**KIRKLEES METROPOLITAN COUNCIL
INVESTMENT & REGENERATION SERVICE**

DELEGATED DECISION TO DETERMINE PLANNING APPLICATIONS

Reference No:	2024/62/93117/E
Site Address:	8, York Place, Cleckheaton, BD19 3PA
Description:	Erection of two storey extension
Recommending Officer:	Faiza Bano

HOUSEHOLDER DELEGATED REPORT

PROPOSED FIRST FLOOR PLAN

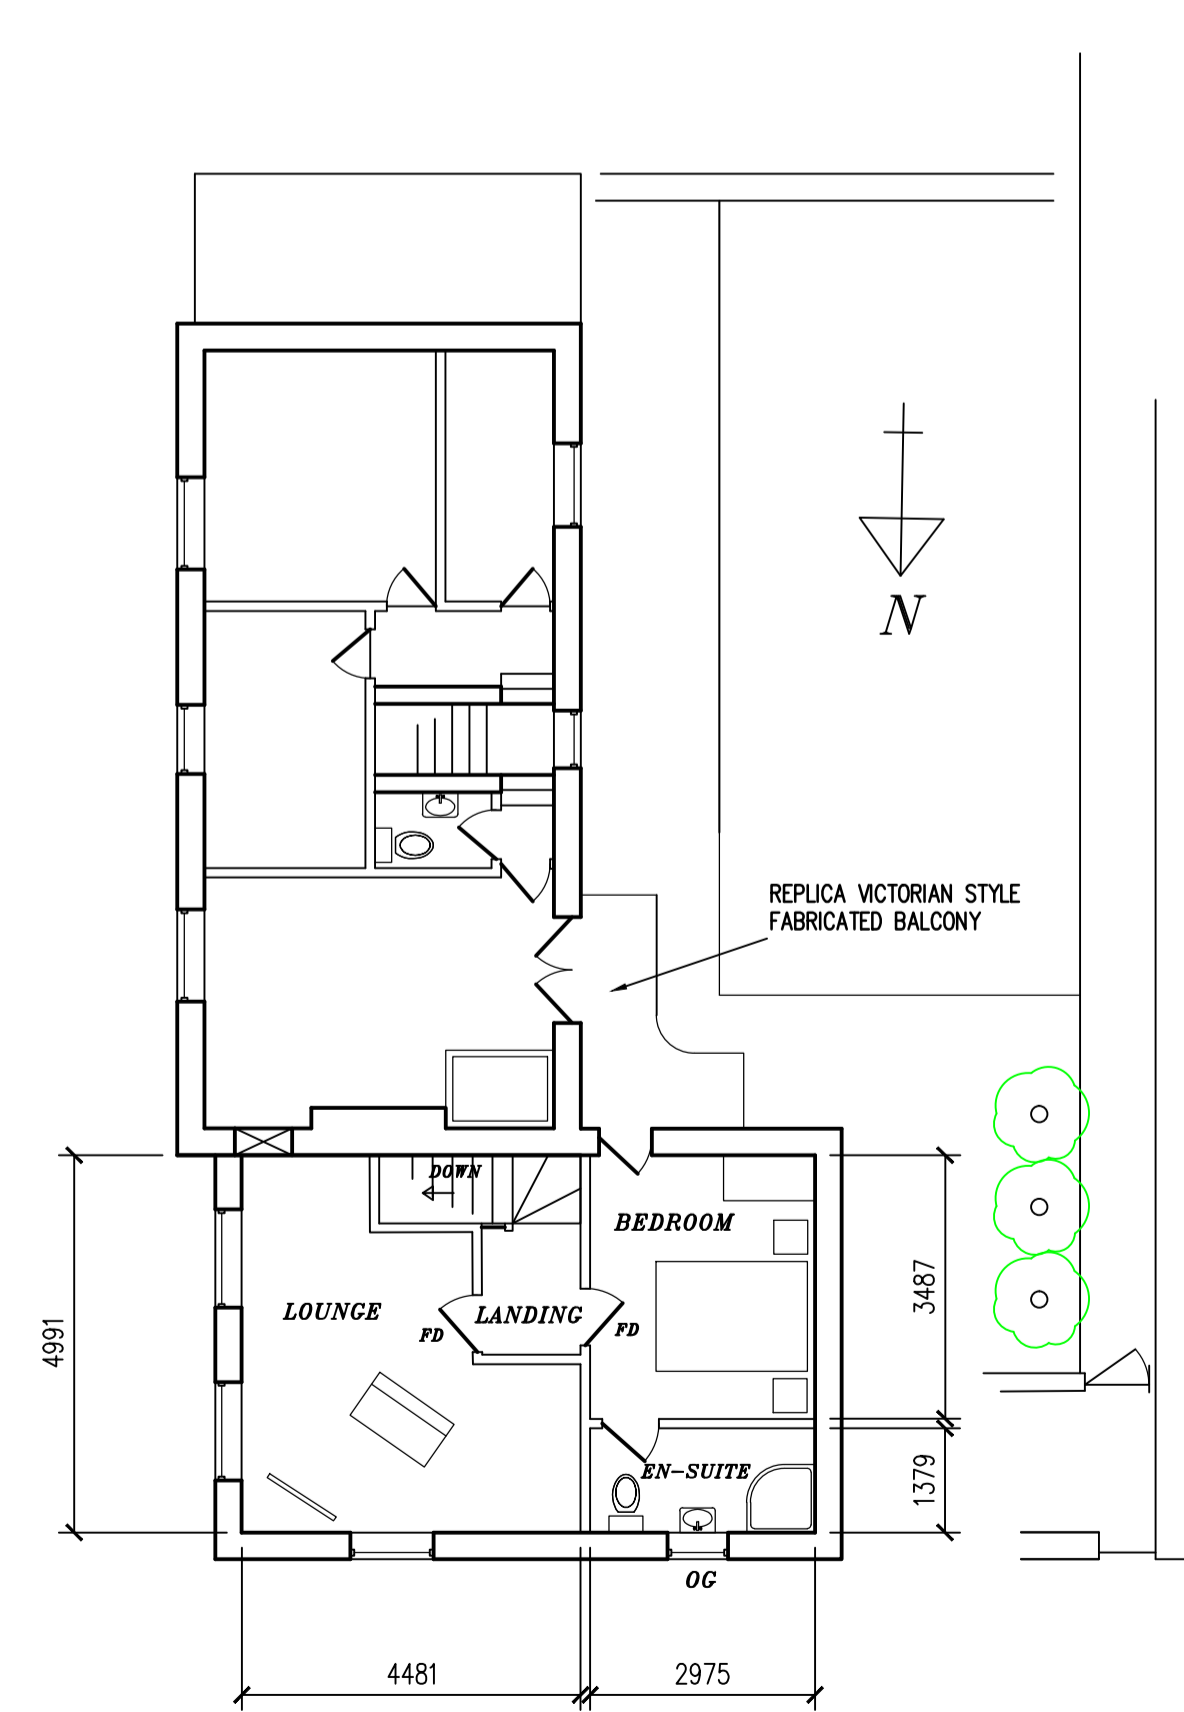
Two Storey Side Extensions Should:	<u>Yes - COMPLY</u>	<u>No - JUSTIFY</u>
not take up all or most of the space to the side of a house;		No – the proposed extension projects out by approximately 5 metres. The design and scale are in keeping with the character of the area. No significant adverse effects will occur on neighbouring properties due to the application site being a corner plot. The extension provides essential space and functionality. Considered acceptable.
maintain a 1 metre gap to the side boundary to ensure the building is not too close to a		No – the application site is detached and the proposed development will include and build above

neighbouring property; and		the garage which is located along the boundary. The side elevation of this property will be in line with 72 High Street.
be set back at least 500mm from the front wall of the house.		Set back 490mm from the front wall and set below the original ridge line - considered acceptable.

Balconies and roof terraces should be:	<u>Yes - COMPLY</u>	<u>No - JUSTIFY</u>
Positioned, and screened if required, so that they do not overlook neighbouring homes or gardens.	The proposed balcony will be positioned between the proposed two storey extension and northern corner of the existing dwelling. The rear boundary is screened by a very large hedge and the openings facing the rear of the application site from neighbouring properties are considered non-habitable. The positioning of the proposed balcony will not raise any concerns for privacy and overlook neighbouring homes.	
Sited away from locations that are sensitive to additional noise levels or disruption.	Yes – the extension is residential and will not be disproportionate to the site and neighbouring areas and is sited away from areas that are sensitive to additional noise levels or disruption. The balcony is located to the rear of the property on a slight slope overlooking the rear garden.

Roof style	<ul style="list-style-type: none"> • KDP 1 and 2 of the SPD • Policy LP24 Design (a), (c) and (d) of the KLP • Chapter 12 of the NPPF 	Hipped roof style to extensions. The two-storey side extension features a hipped roof. The roof style is acceptable as it is in-keeping with the original roof style of the host property.	✓
Window proportions	<ul style="list-style-type: none"> • KDP 1 and 2 of the SPD 	Modest size windows in extensions, which would	✓

In this application, the proposed development includes a side extension, which effectively addresses the previous visual amenity concern, specifically from the main road. The extension ensures that the balcony will not be visible from the road, thereby preserving the visual amenity of the area.

Furthermore, an assessment of the floor plans for properties at the rear reveals that the openings are for non-habitable rooms, specifically a stair landing and a bathroom. The bathroom window features frosted glass, which significantly reduces any potential privacy issues.
